Planning Application Reference No.: 3/2025/0316

Address of Development: 27-29 Bawdands Clitheroe BB7 2LA

Planning App Ref: 3/2025/0316 Proposed change of use from (Use class E / Use Class C3) to House in Multiple Occupation with six rooms (Use Class C4).

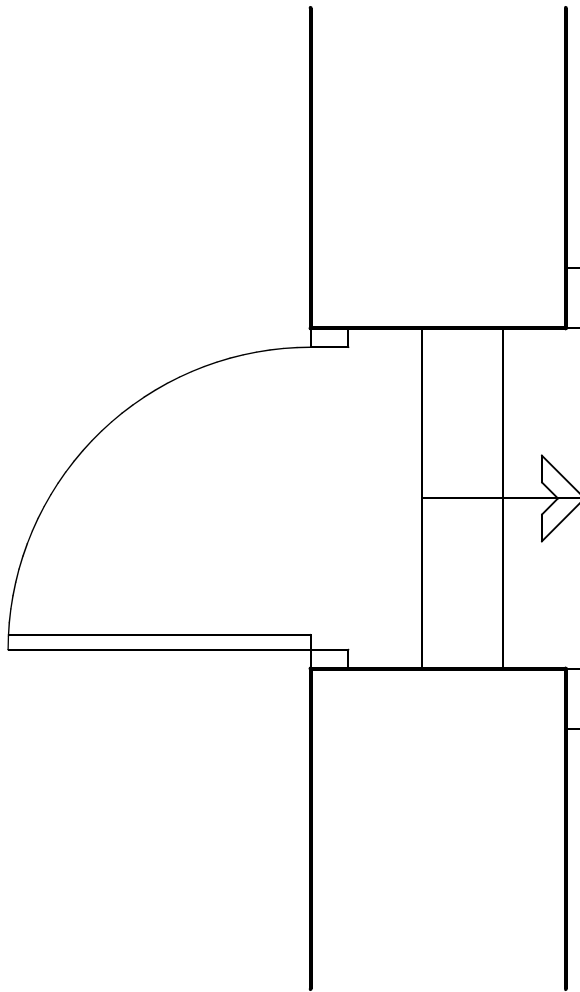
Compounding the above problem are two further issues, 1) The jambs of the internal and external door openings are around 750mm and 550mm respectively, from the wall the bicycles would be hung from, resulting in the aisle between the two door openings being impacted by the Bicycle Envelope. 2) The store is accessed by an external recessed single door with 3 steps rising approx 500mm. In short the store is not big enough.

4.4: The potential problem with the door opening, and significantly, the defined problems with the 3 external steps and gradient remains.

4.5: In attempting to overcome the identified issue of the steps, a portable ramp has been indicated. There is no specific detail of the ramp in the application documents, however, a ramp directly down the pitch of the 3 steps would have a gradient of circa 1 in 1.36, which would be totally unsuitable for the manoeuvring of fully laden wheelie bins, it would constitute a danger for the operative and a danger for passing pedestrians on a busy pavement.

An extended ramp (approx 1300mm long) to manoeuvre the bin onto the pavement without going onto the highway would lower the gradient to around 1 in 2.5, again too steep and would totally block the pavement, being disruptive and dangerous to pedestrians.

To compound the problem of the steep gradient of a ramp, there would be a cross fall across its width at the bottom of the ramp as the pavement itself has a gradient falling from Bawdlands along the length of Corporation Street, this would render any portable ramp unstable.

To put it into perspective, the maximum gradient for access into a building under Building Regulations is 1 in 12. Applied to the access into the bin / cycle store this would mean a ramp of no less than 6.0 metres long would be required, which would be impractical and unachievable. A portable ramp is not therefore, a feasible solution.
